Our Ref: 5/2020/PLP
Your Ref: SSD-10472

Comments on the Expansion of the Museum Discovery Centre (SSD-10472)

Thank you for the opportunity to provide comments on the State Significant Development relating to the expansion of the existing Museum Discovery Centre at 2 Green Road and 172 Showground Road, Castle Hill.

Figure 14 Proposed relocation of TAFE parking spaces

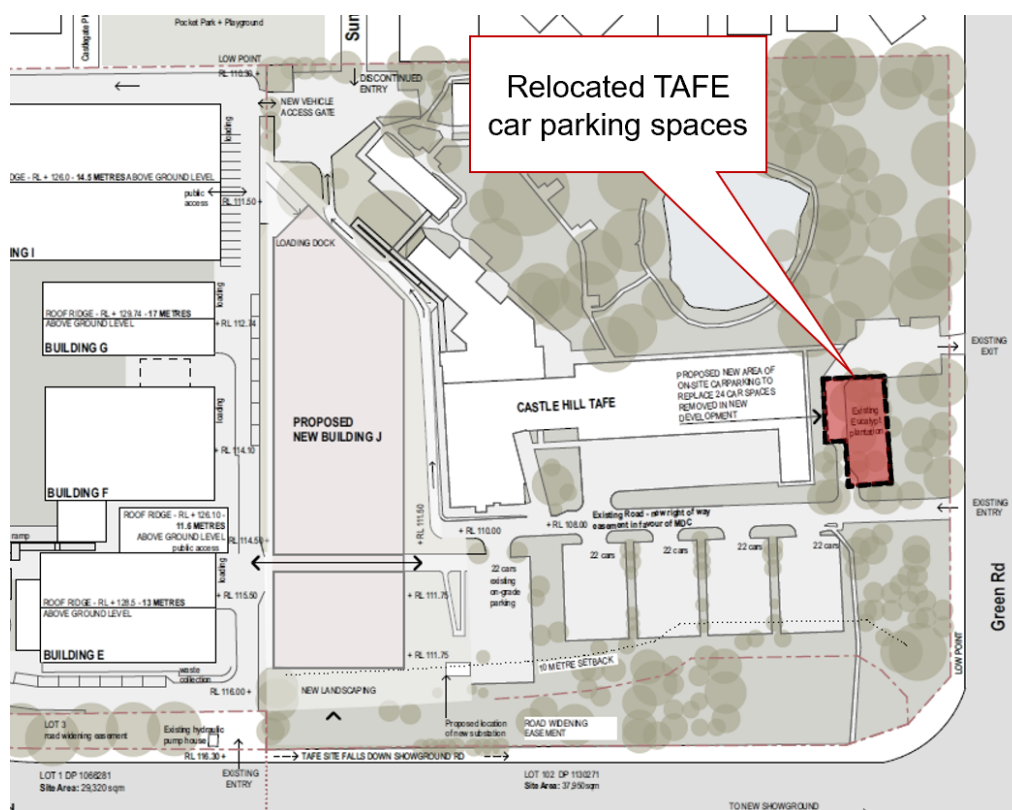
Notwithstanding the above, the EIS indicates that the 38 informal car parking spaces would be relocated elsewhere throughout the TAFE site to satisfy Condition 2 of the consent for DA 1674/2007/HA. However, no plans have been submitted to identify the location of these parking spaces, nor has this been addressed in the supporting TIA. Clarification is sought on this discrepancy and as to whether the relocated parking will remain sealed or unsealed.

Figure 16 Building J loading dock

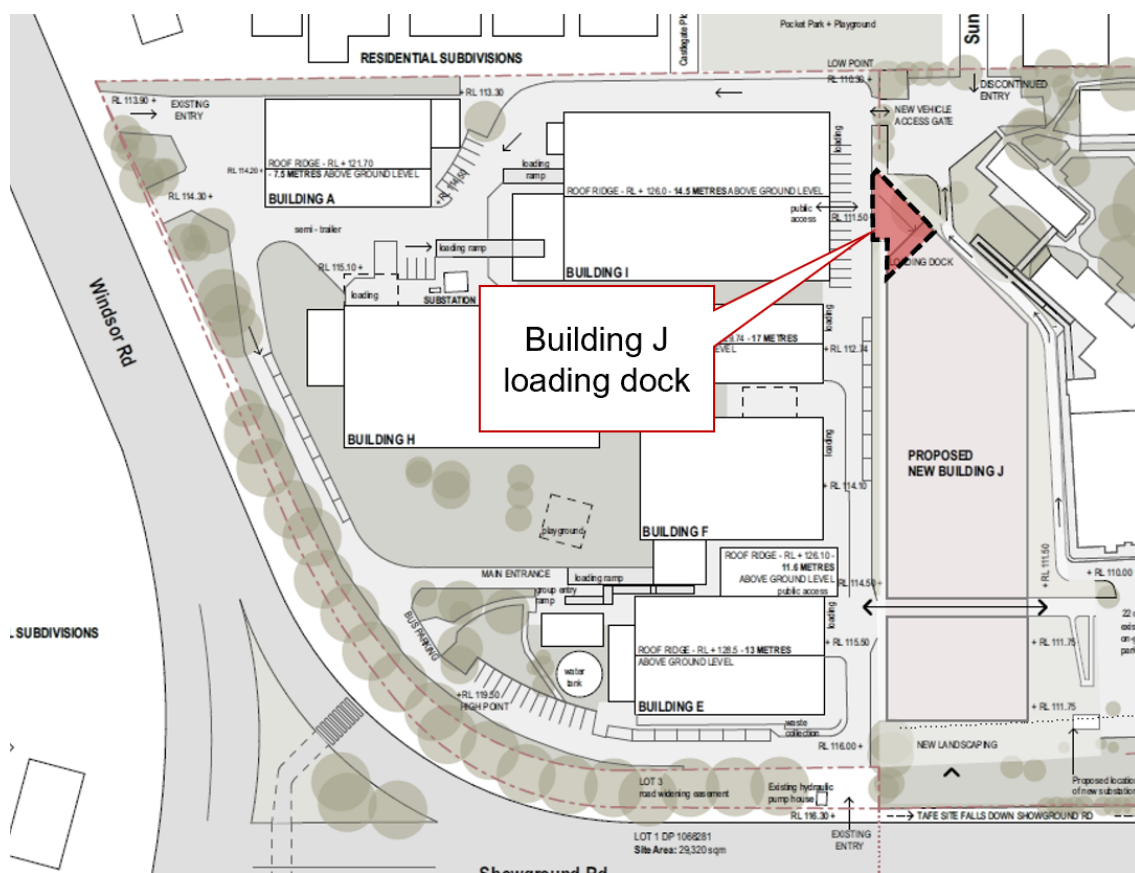
The supporting Acoustic Report identifies evening and night truck noise emissions will exceed the criteria of 43dBA and 38dBA respectively when entering and exiting the northern loading dock. This may result in detrimental noise impacts to residential properties on Peppertree Place and Sunderland Avenue. It is noted that noise mitigation recommendations included in Section 7.4.2 of the Acoustic report is considered appropriate, given the small to medium size vehicles, relatively infrequent delivery times and their minimal maneuvering and idling outside the loading dock.

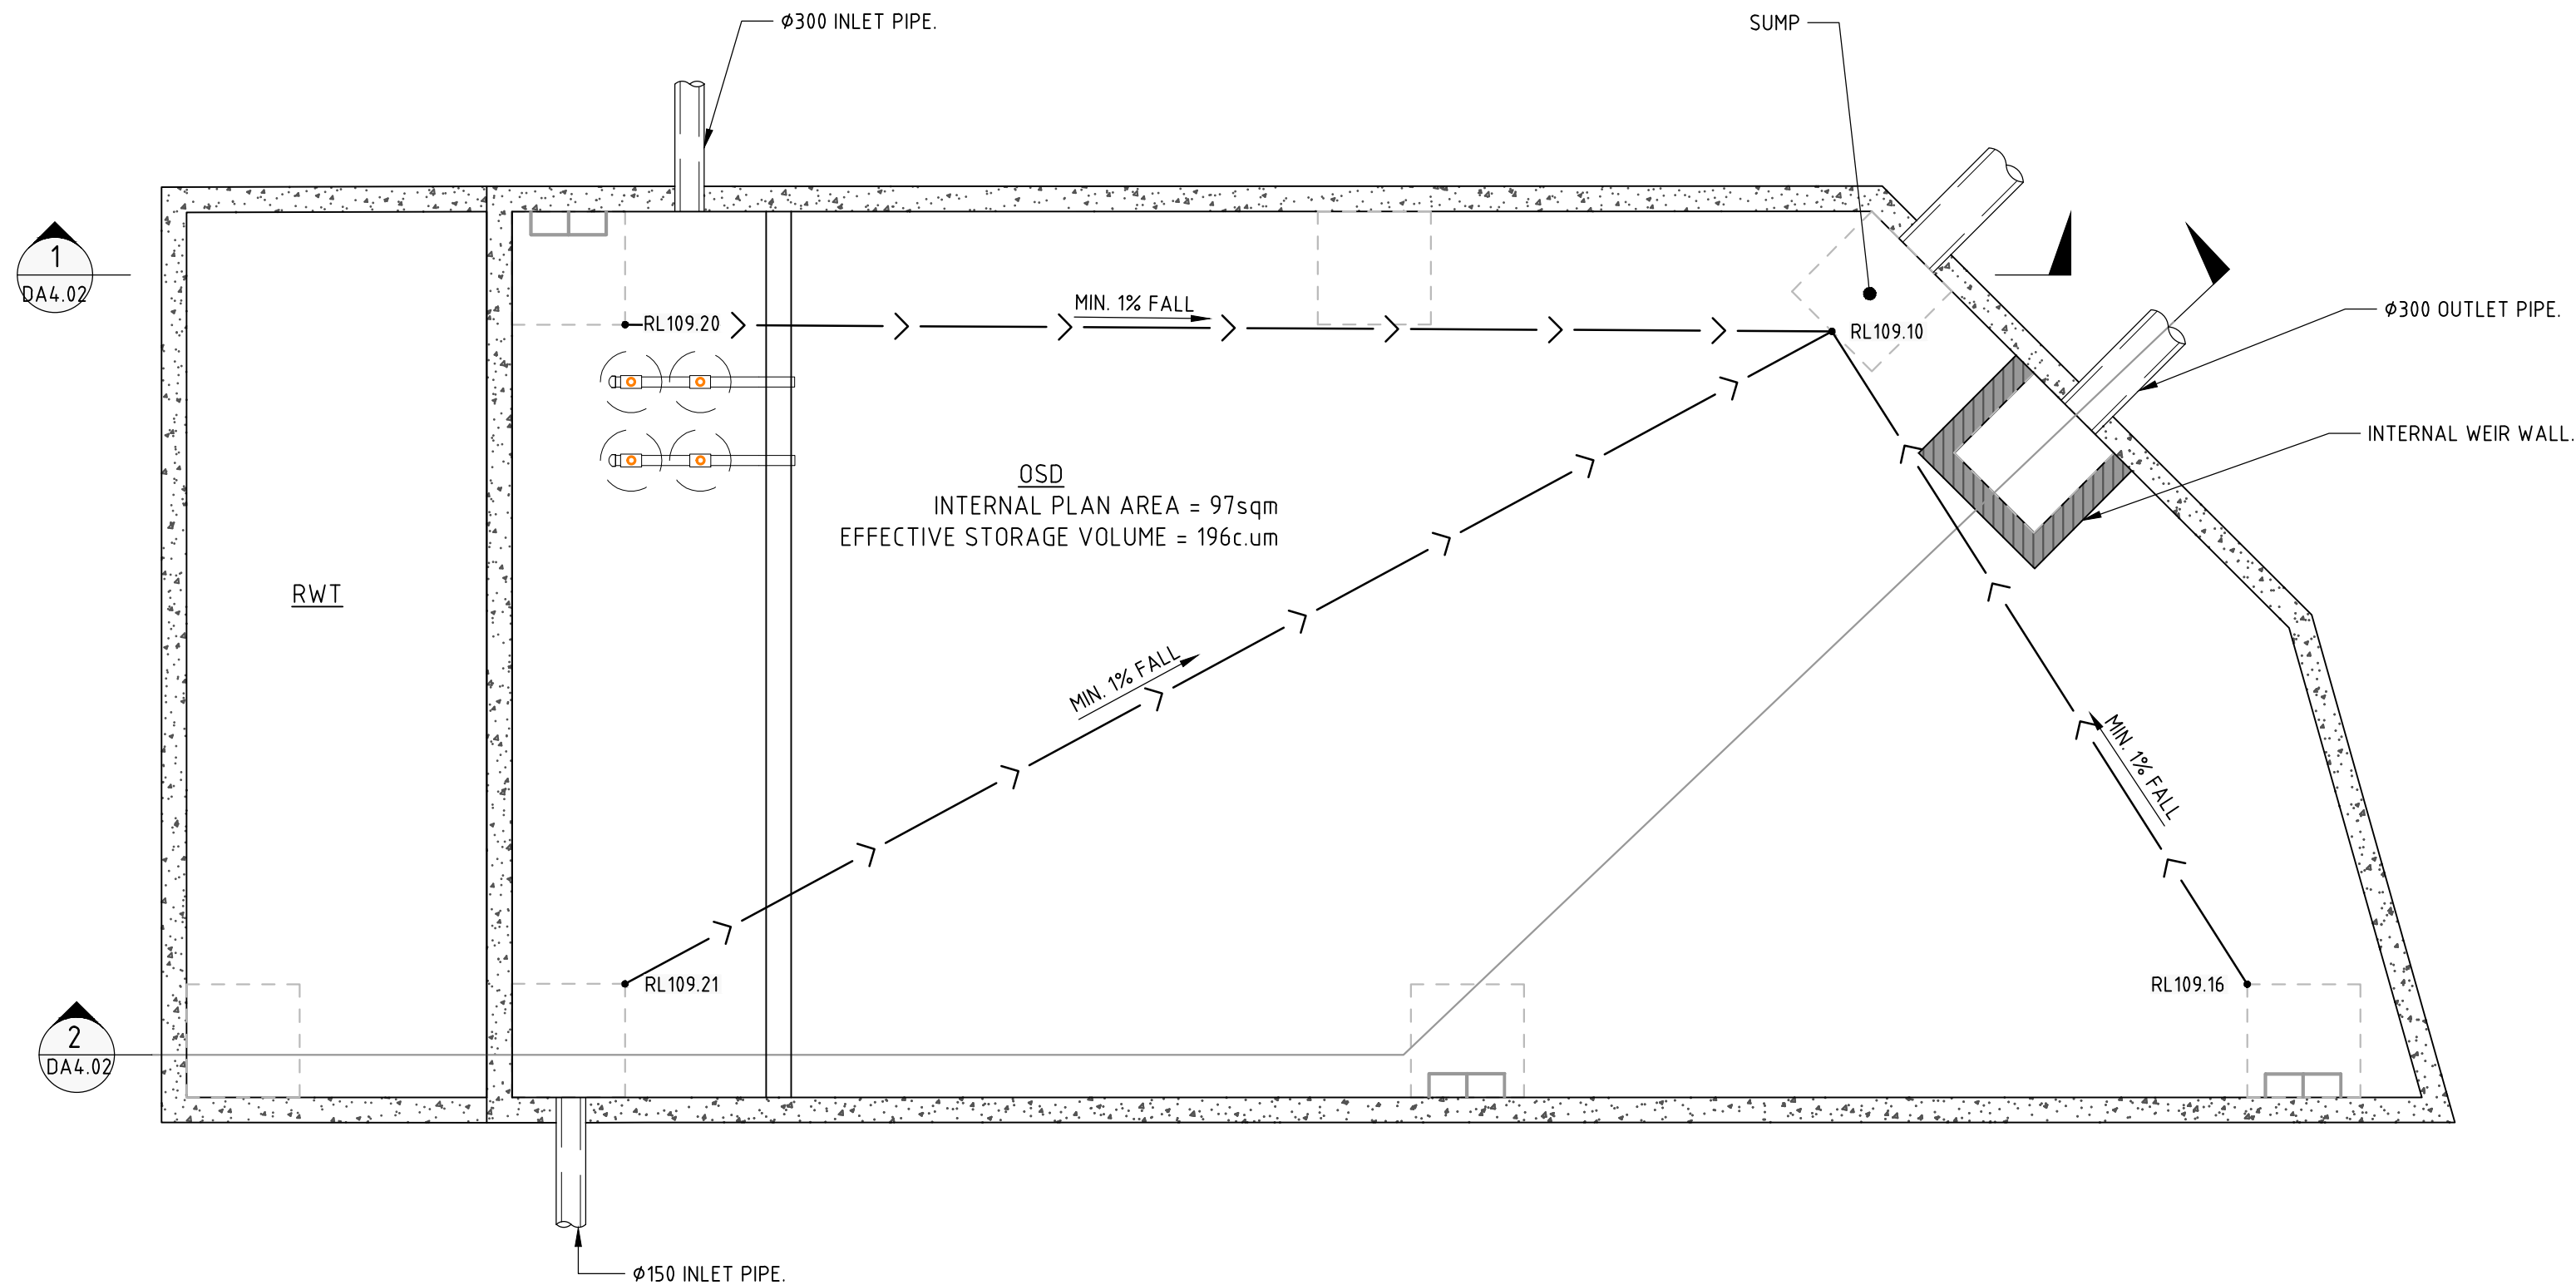
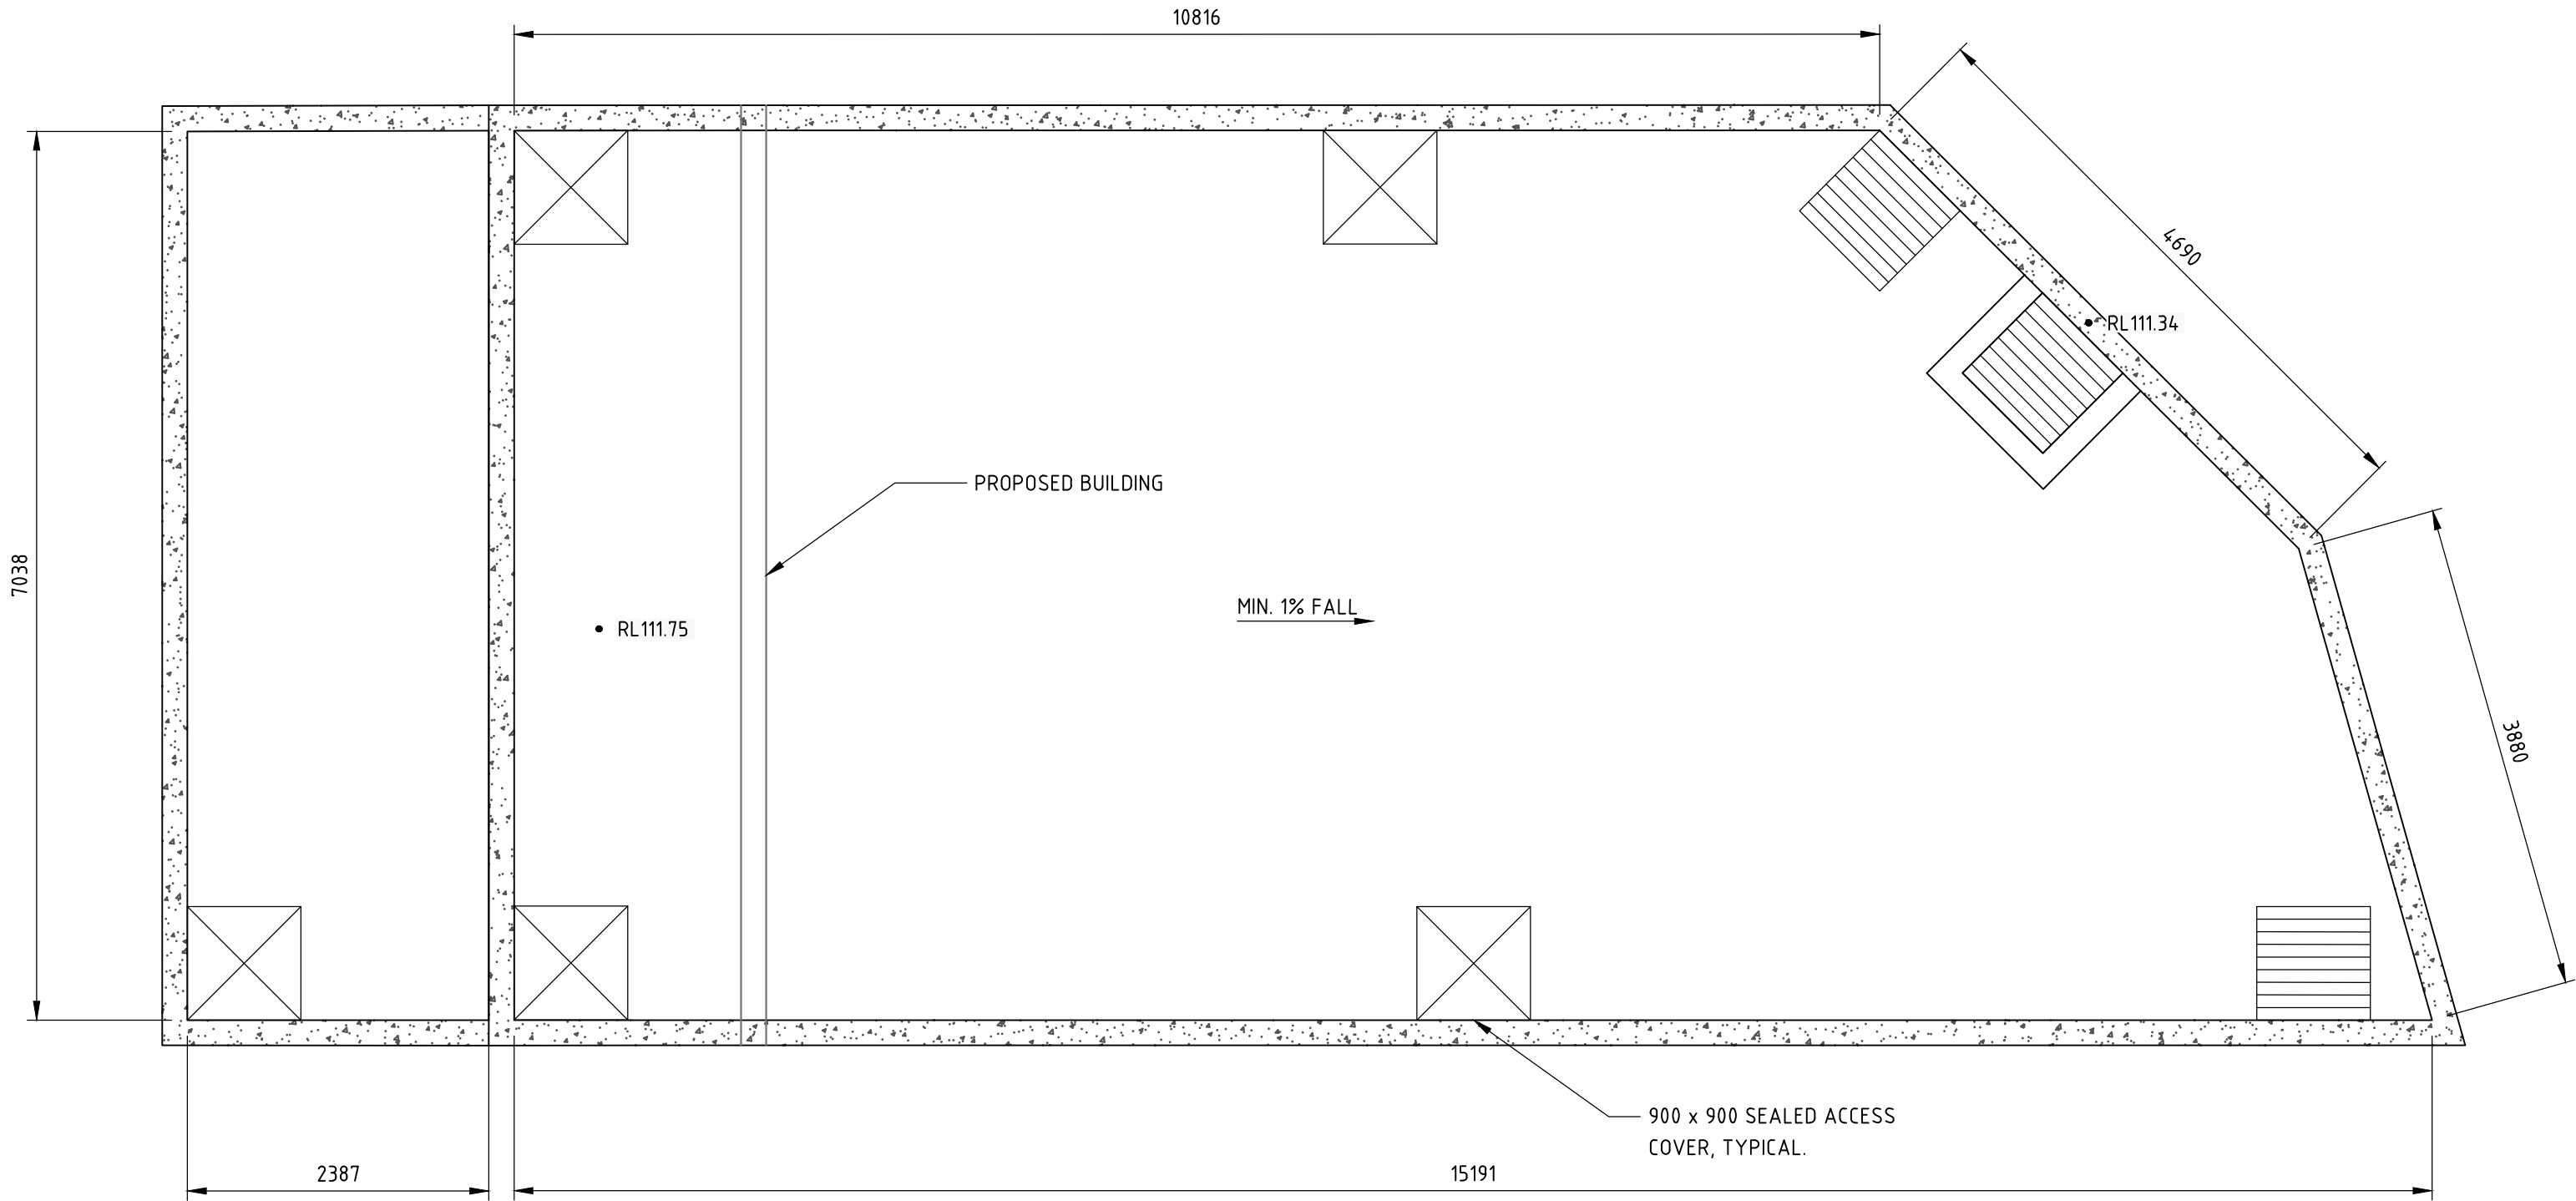
It is noted that the Stormwater Management Report has used Version 4 of the Upper Parramatta River Catchment Trust for the on-site stormwater detention (OSD), being a dual orifice design. However, Section 2.4.1 of the report refers to site storage requirement (SSR) and permissible site discharge (PSD) from Version 3 which requires a high early discharge (HED) as opposed to dual orifice as shown on plan. Justification is required for where the additional SSR and PSD of 260m³/ha and 25L/s/Ha is derived from (as identified in the OSD calculation sheet), as no allowance for dual outlet design within the Hawkesbury Catchment is provided for within Version 4 of the Upper Parramatta River Catchment Trust Handbook.

Accordingly, the proposed OSD tank has been designed with two separate PSD & SSR parameters along with twin basin outlets (refer to Plan No DA4.01, Rev 2) instead of Council's required single outlet as per Hawkesbury River Catchments OSD requirements. In accordance with Table 4.14 of Council's design guidelines for subdivision/developments, the OSD tank is to be amended and designed considering one SSR & PSD parameter with a single basin outlet connected to downstream drainage system.

Further, consideration should be given to the following key OSD tank hydraulic design criteria in the overall design of the tank for satisfactory performance:

- Downstream tail water levels against proposed tank hydraulic performance to be demonstrated during frequent and major storm events;
- OSD tank volume calculation table should be presented in the OSD detail design plans; and
- The proposed overland flowpath from the OSD tank ought to be identified towards downstream formal drainage system and to be clearly shown in the design plan as per Trust OSD handbook for implementation.
